Application for a Non-Material Amendment Following a Grant of Planning Permission

Internal alterations to move disabled access room to ground floor with accessible en-suite, with single storey extension to rear to form utility and kitchen area

23/01373/FUL

change window proposed in the gable wall of the extension to the utility room to a disabled access door with ramped access

FIRST FLOOR PLAN AS PROPOSED

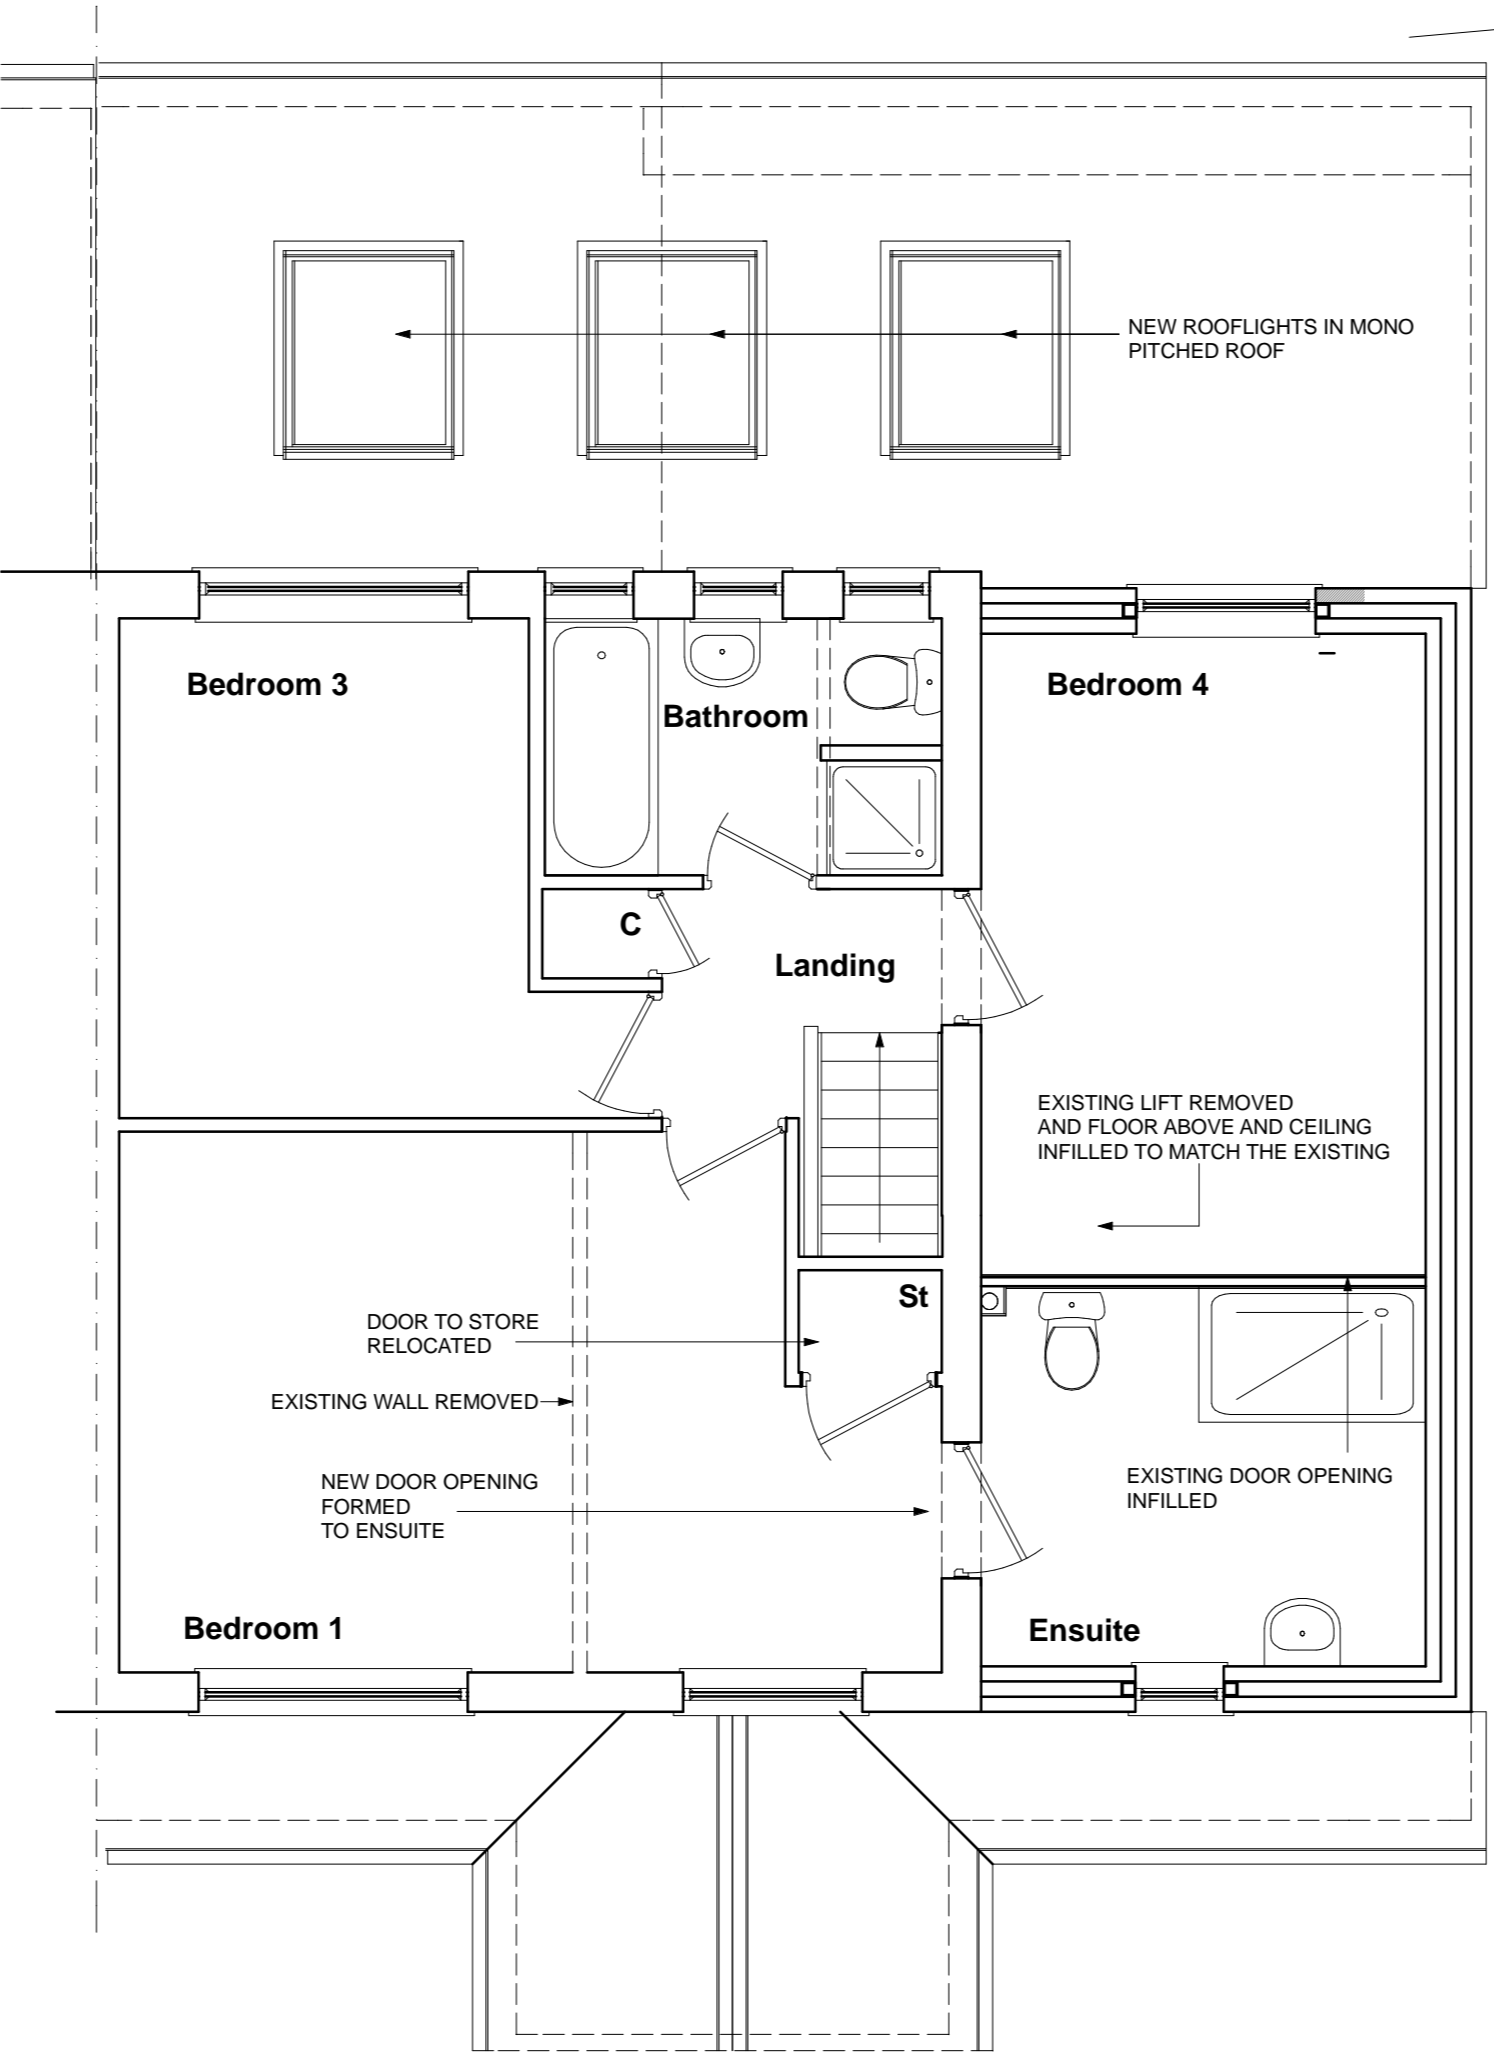
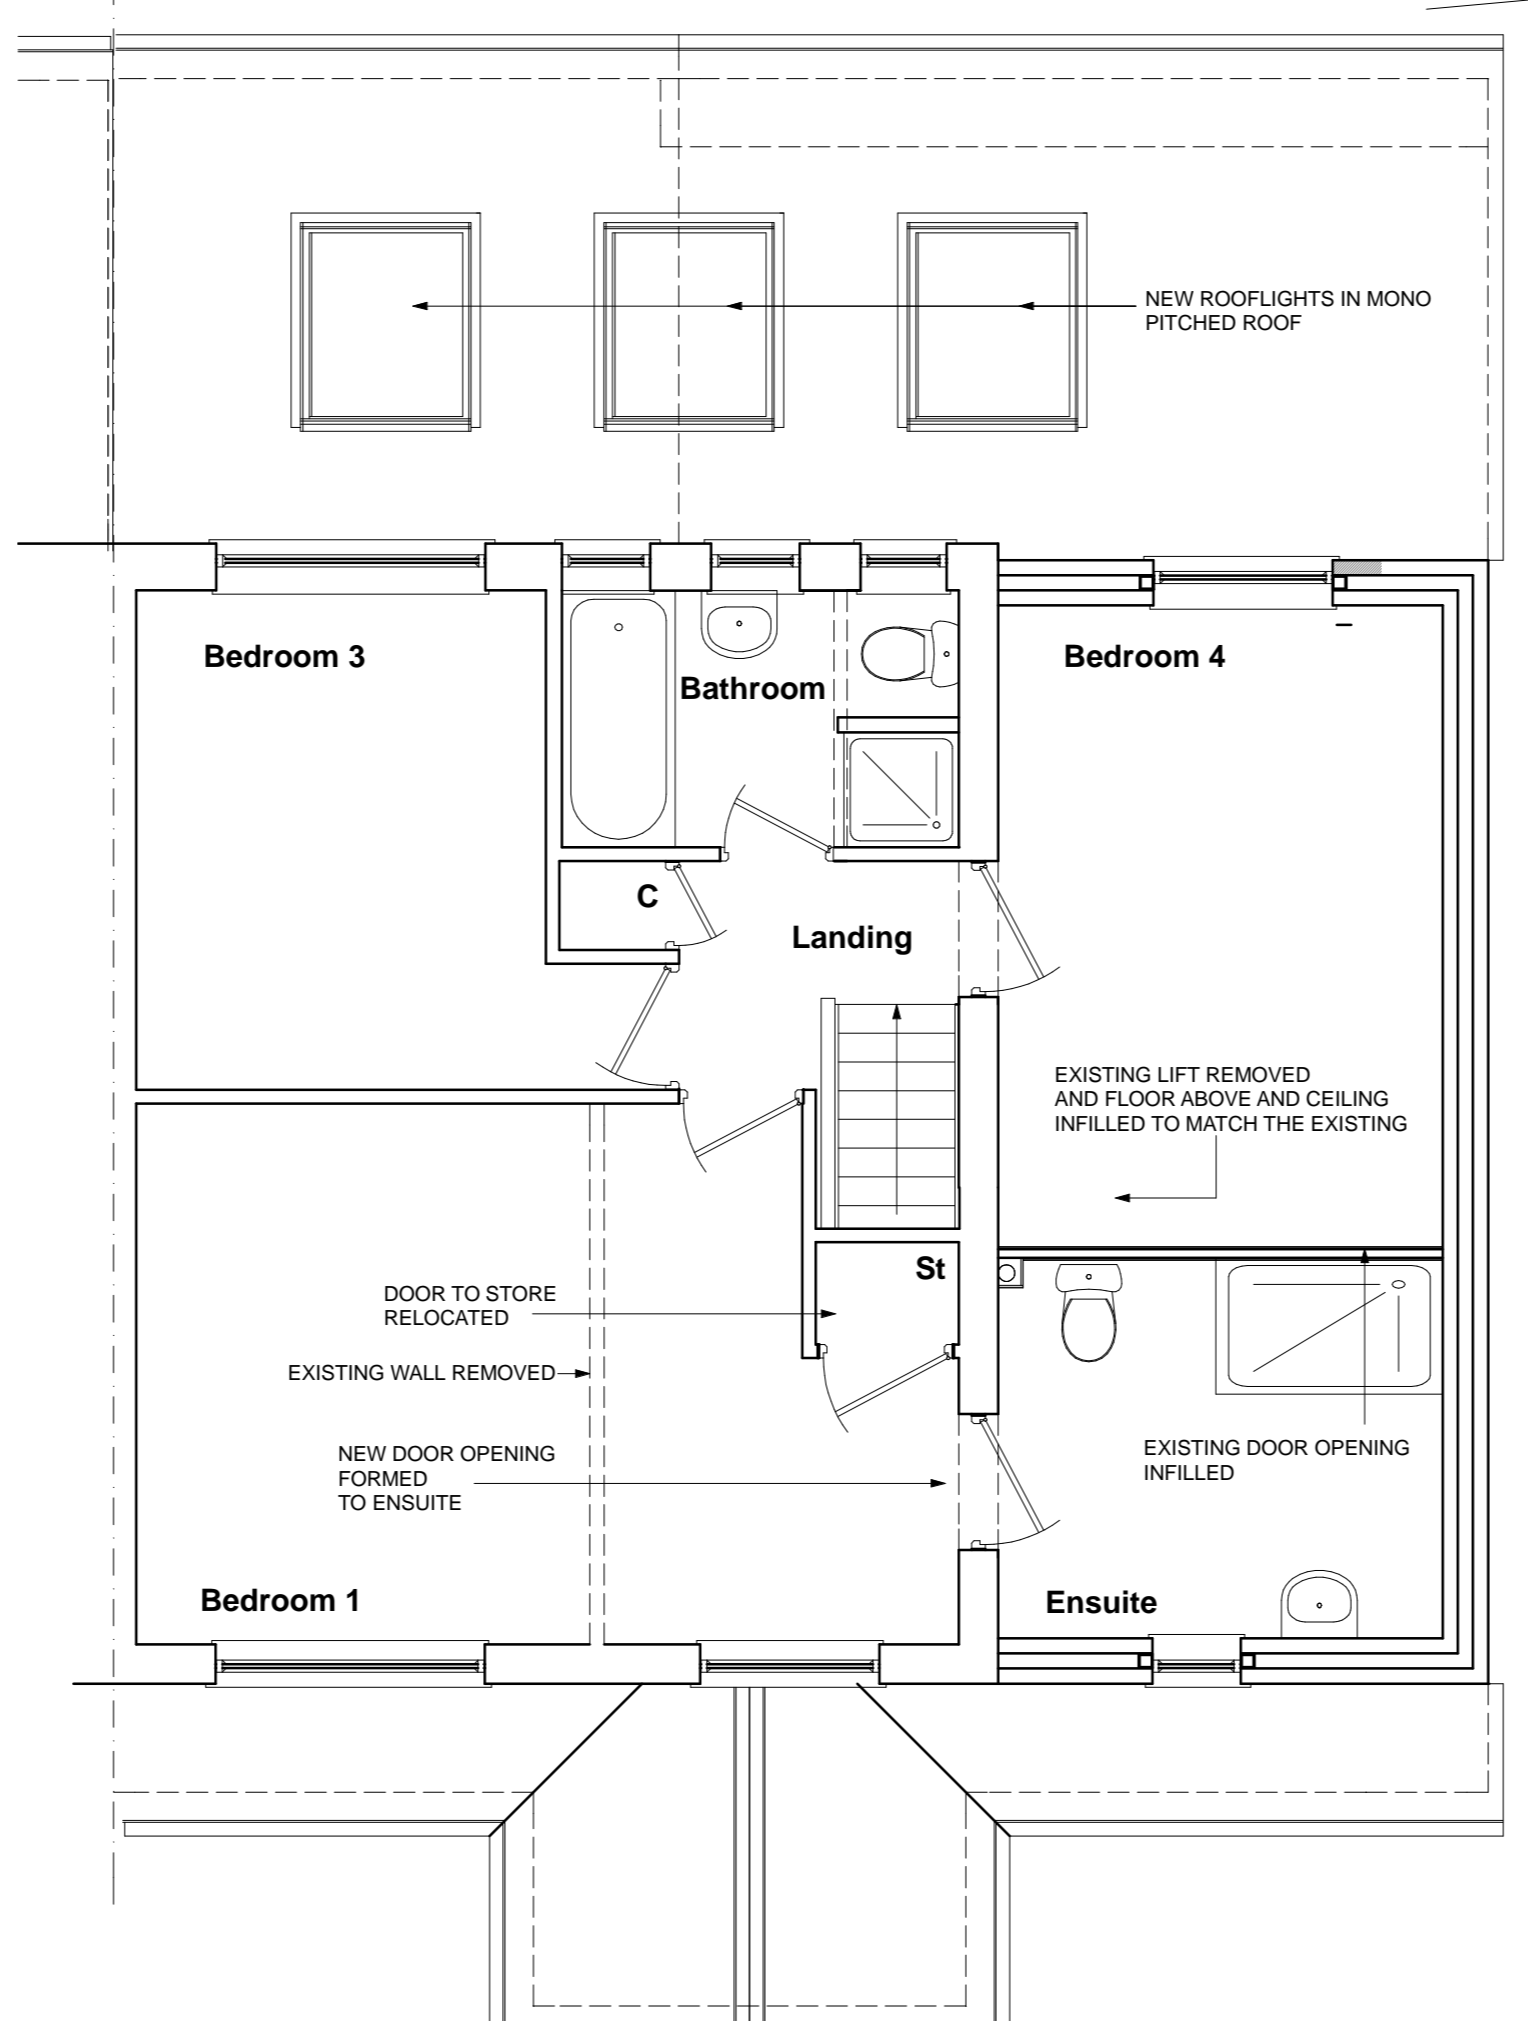
After review the applicant considers that a more direct wheelchair accessible entrance adjacent to where the cars are located would be more practical
